From: Siobhan O'Brien <SOBrien@wicklowcoco.ie>
Sent: Monday 28 April 2025 16:12
To: Derek Kelly
Subject: ABP-321578-25

I refer to ABP-321578-25 – application for substitute consent under section 177E for rock quarry at Hempstown Commons, Blessington, Co. Kildare.

Please find below observations from the Road Engineer,

OFFICE CONTAINER, WEIGHBRIDGE, WHEELWASH AND WHEELWASH RECYCLING TANK DETAILS

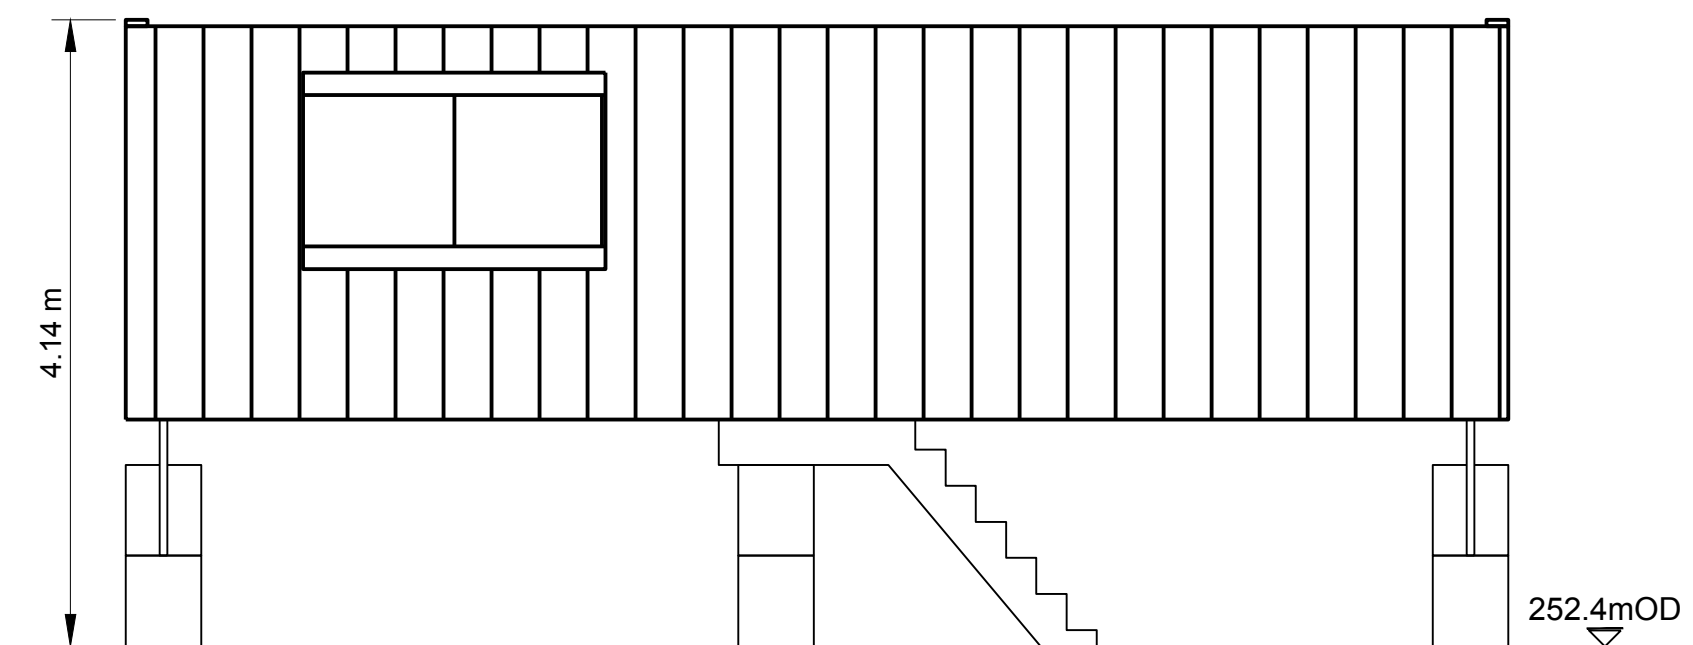
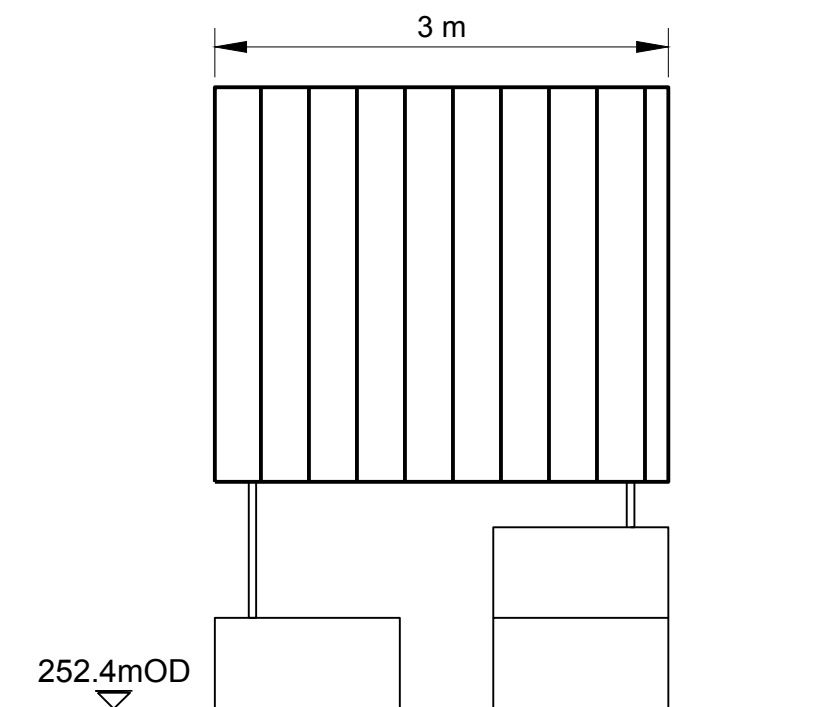
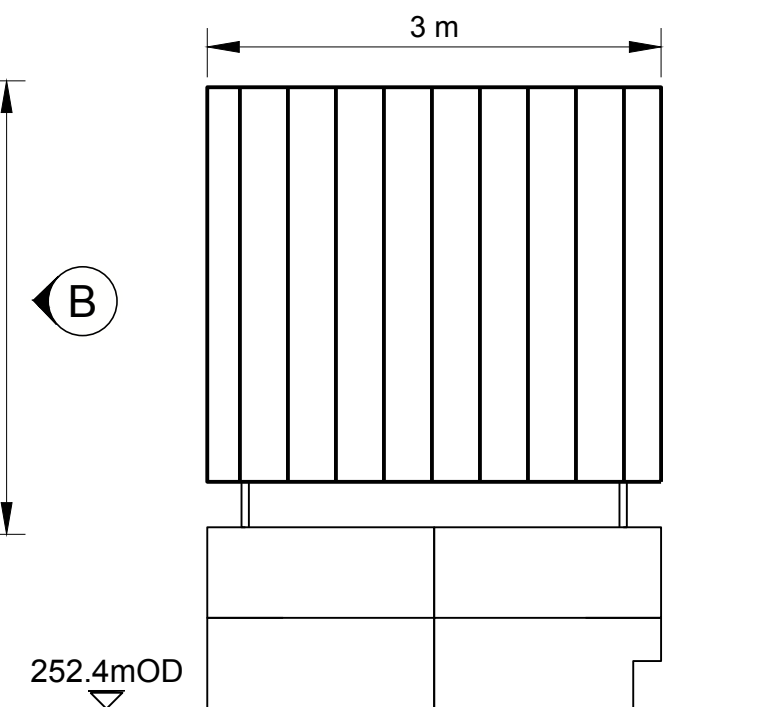
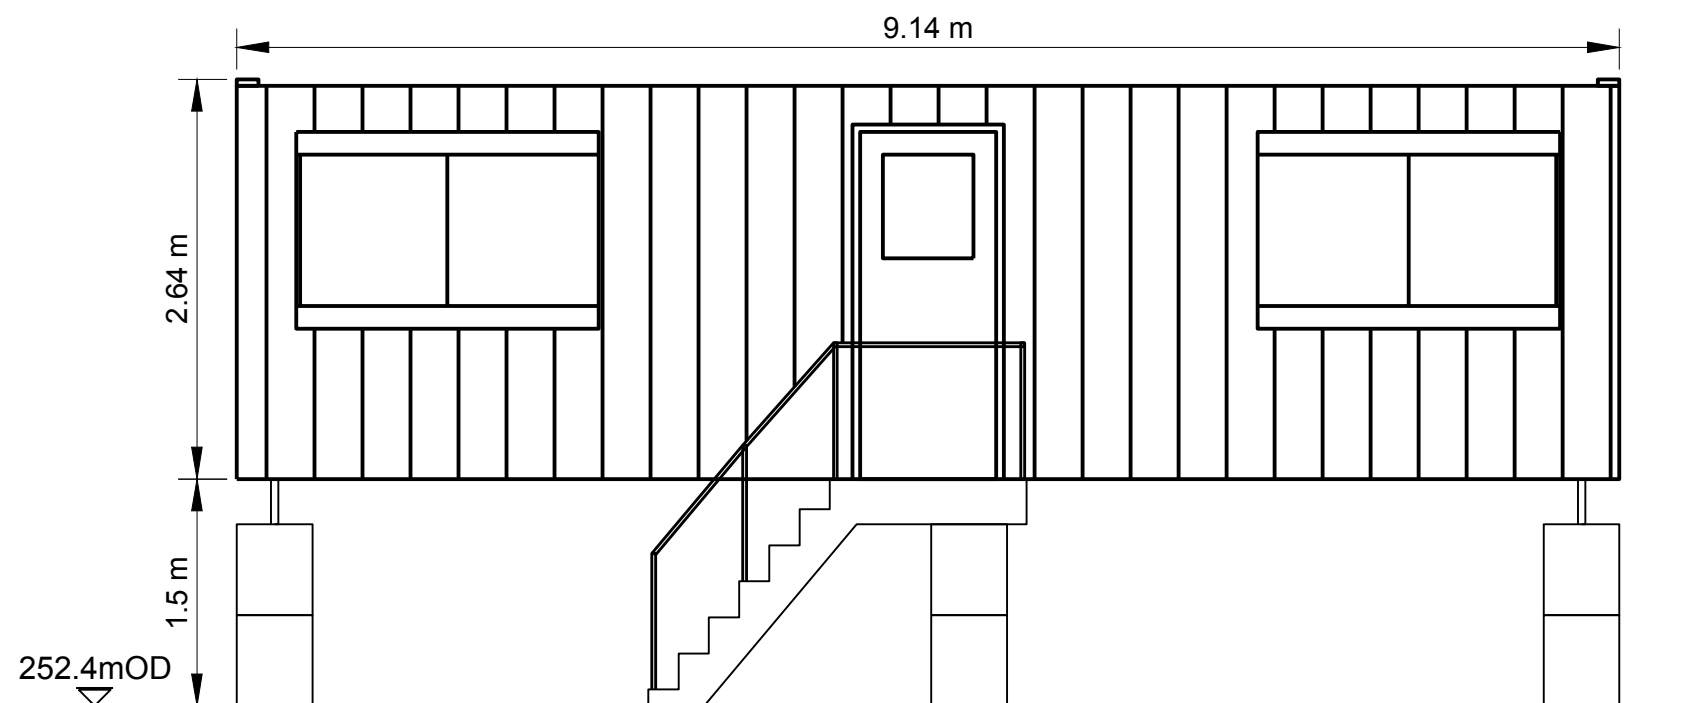
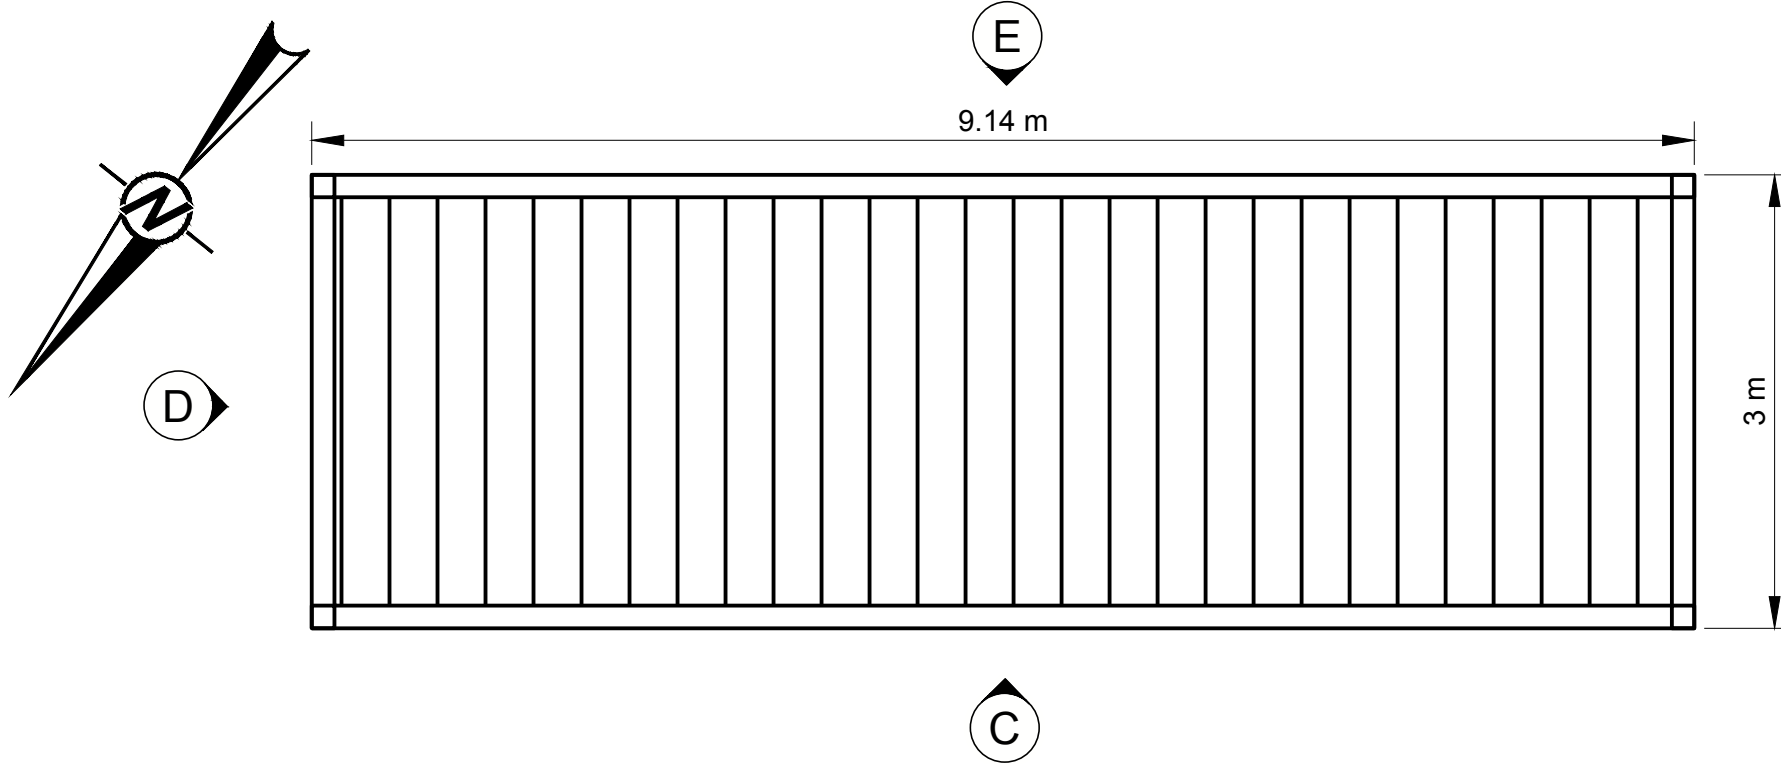
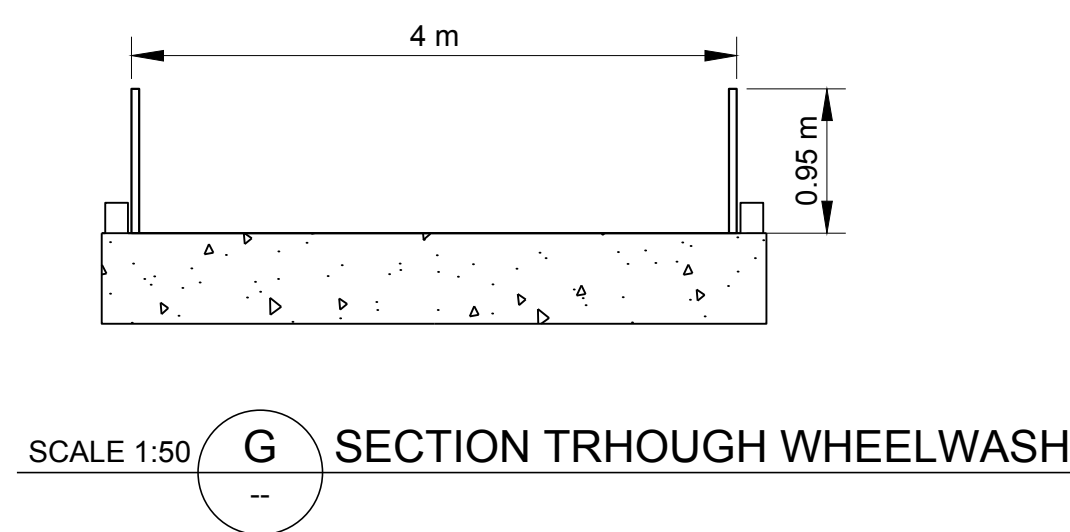
- The N81, being a national route, is affected by dirt and debris from nearby quarry operations. This creates significant recurring safety issues along the N81 as road makings and studs become obscured and skid resistance is reduced. Although this application is not solely responsible for the debris on the N81, it is recommended that enhanced vehicle and truck washing facilities be provided to mitigate the impact on the N81.
